## 30 Merrill Street - Final Traffic Comments

Hi Nell – The following represent a status update of my prior comments and represent final traffic comments.

BRICK DRIVEWAY APRON WITH BITUMINOUS BASE
NOT TO SCALE

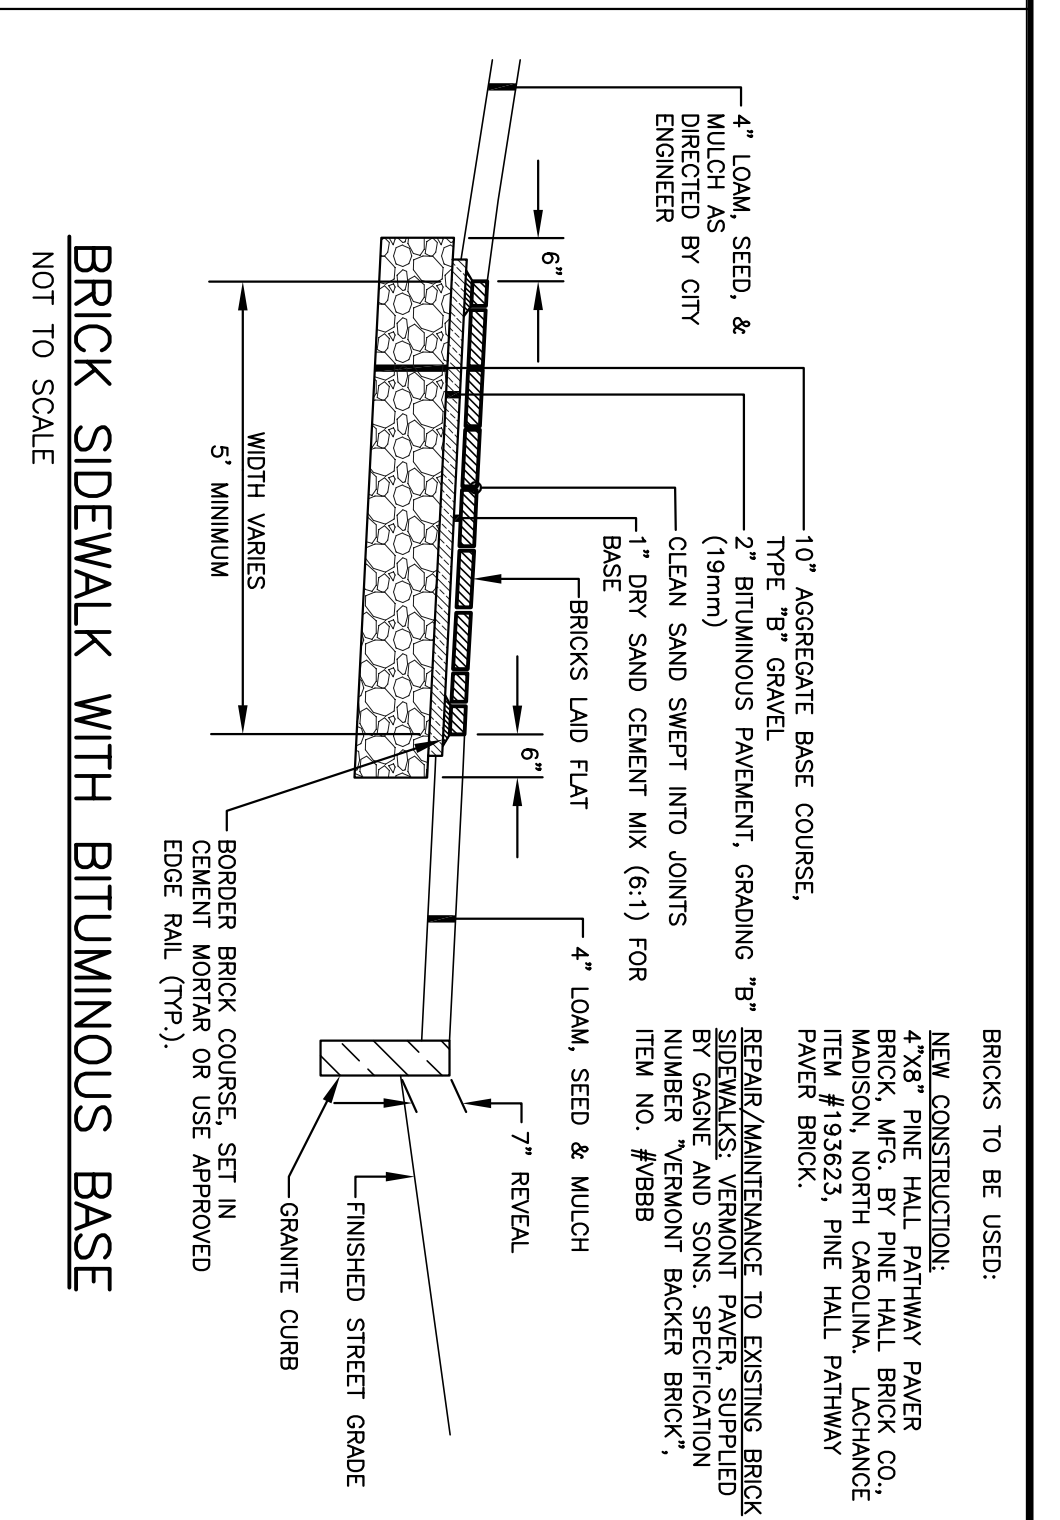
- The site plan depicts the driveway offset from the curb opening, while the existing driveway is centered. The applicant should note why an offset condition is proposed.

**Final Status: The plans have been revised to note that the driveway apron will be upgraded and centered with the proposed driveway. The plan notes a brick driveway apron and I would suggest a condition of approval that requires the project meet driveway design material standards currently being considered for revision by the City Council.**

Status: Based upon the condition of both tip-down curbing and the driveway apron, the applicant shall center and renovate the driveway apron to meet City standards.

13 FENCE DETAIL NEAR CURB  
SCALE: 3/4" = 1'-0"

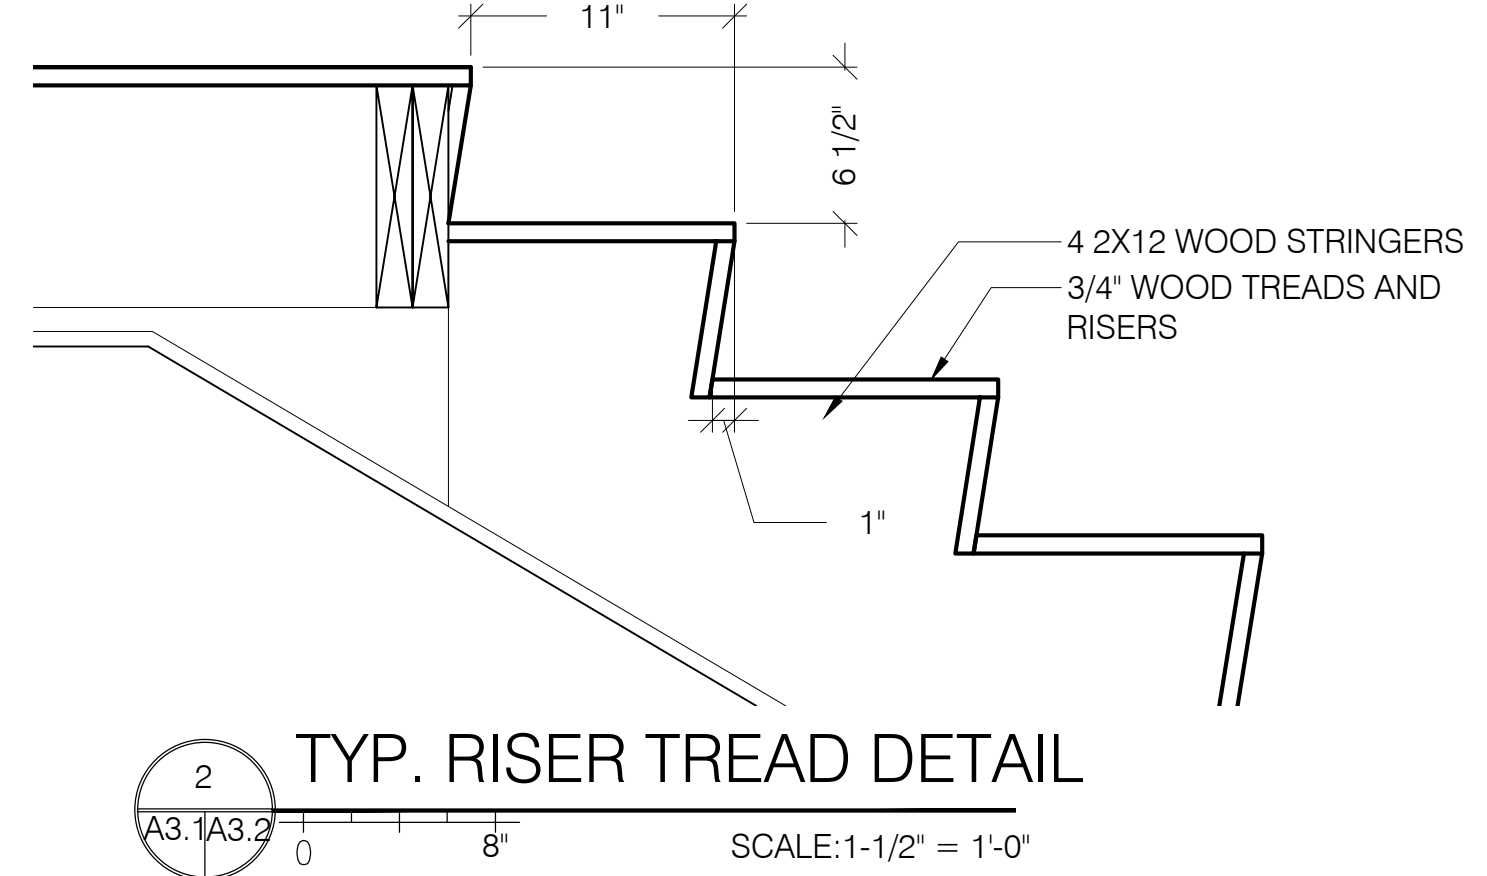
- A fence is proposed on the edge of the driveway. Details on the fence should be provided.

**Final Status: The applicant has provided a fence detail that I find to be acceptable. Given that backing maneuvers are likely, I would suggest that the fence height be reduced to 3.5 feet for the first fence panel from the property line to ensure safe sight lines to pedestrians on the sidewalk.**

PROJECT NAME: SIX-UNIT BUILDING 30 MERRILL STREET
 PORTLAND, MAINE
 SHEET NAME: SITE LAYOUT PLAN

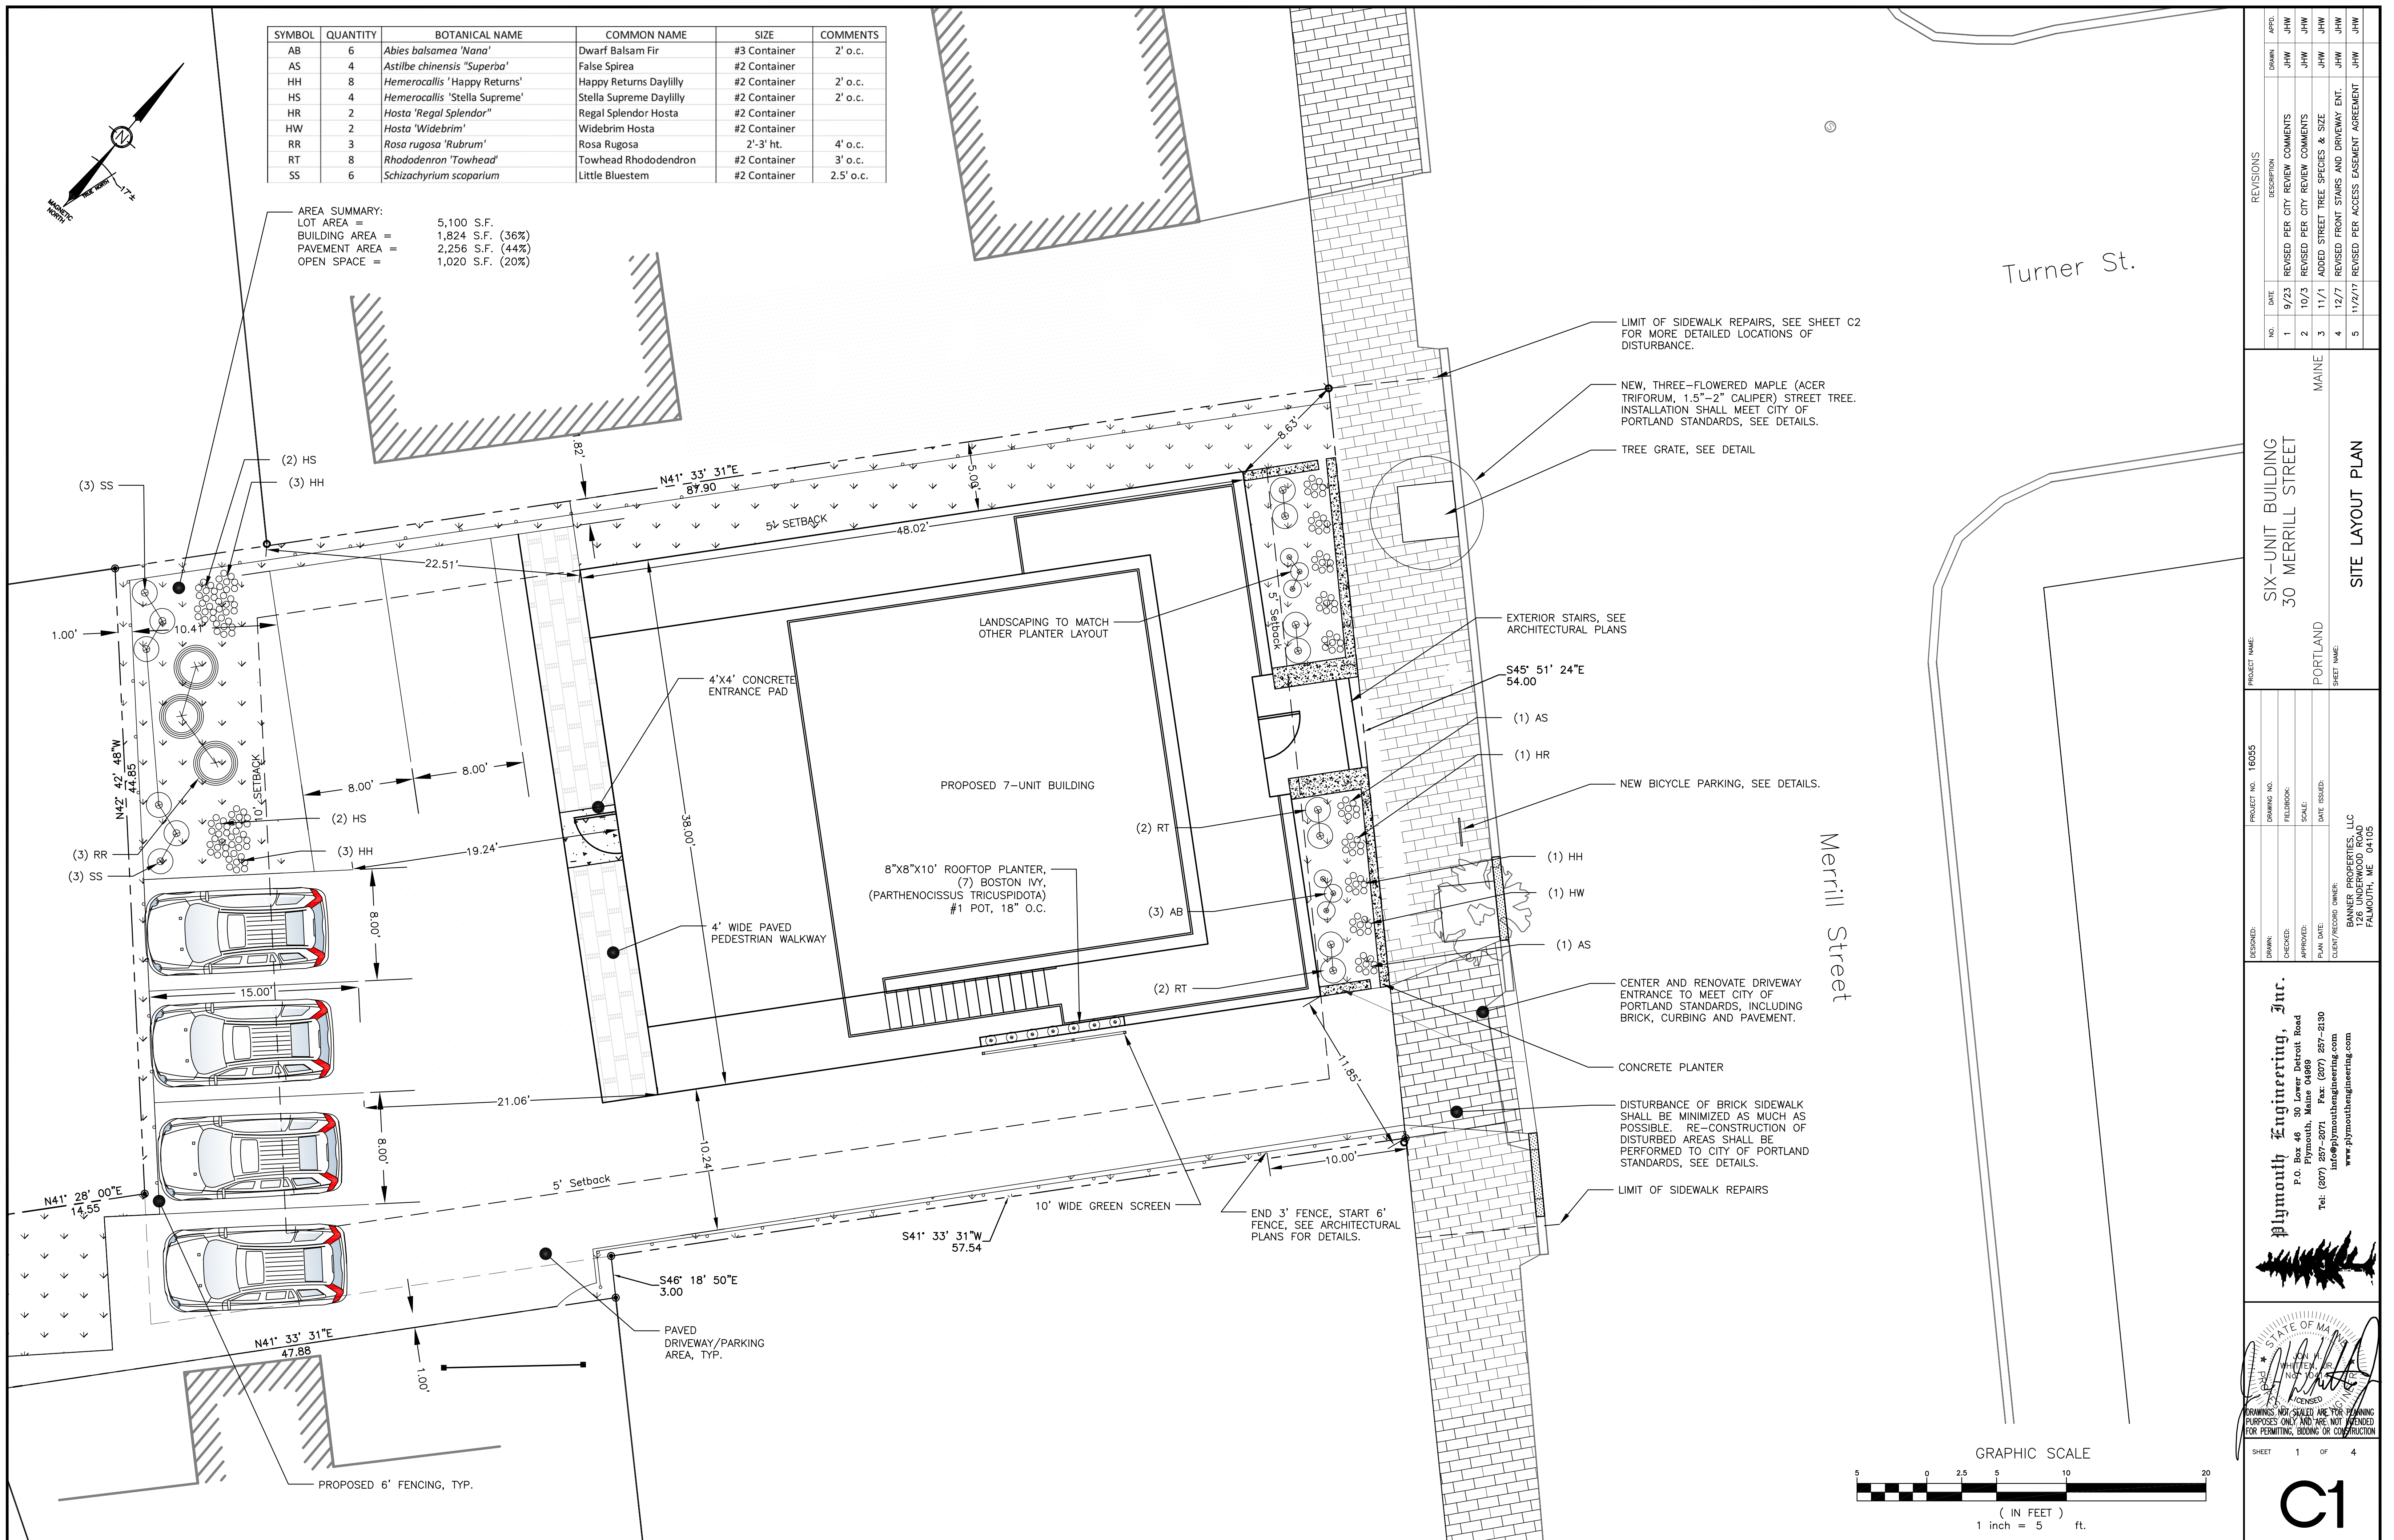
- Access and egress movements from parking spaces will be constrained. The applicant has provided vehicle turning templates that seem to illustrate parking space accessibility is feasible. Given the constrained conditions, I would suggest the applicant simulate the layout in a field test to be reviewed by me. I would note that the parking space adjacent to the handicap space will be difficult to maneuver into and out of.

Status: The applicant has provided vehicle turning template graphics that illustrate movements. Given tight circulation conditions, conflicts with pedestrians entering the building via the driveway and parking lot, I would suggest that the parking lot be designed to minimize conflicts. I would suggest that the parking space adjacent to the handicap parking space be eliminated and used for enhanced circulation space (While I do not oppose backing maneuvers onto Merrill Street, I would prefer that they are minimized). In my professional opinion the site will function adequately by removing the subject space and the previously noted field simulation would no longer be required.

**Final Status: The plans have been revised and I find them to be acceptable. I would note that given site constraints, I support waivers from the City's Technical Standards for aisle width and the provision of**

**compact parking spaces.**
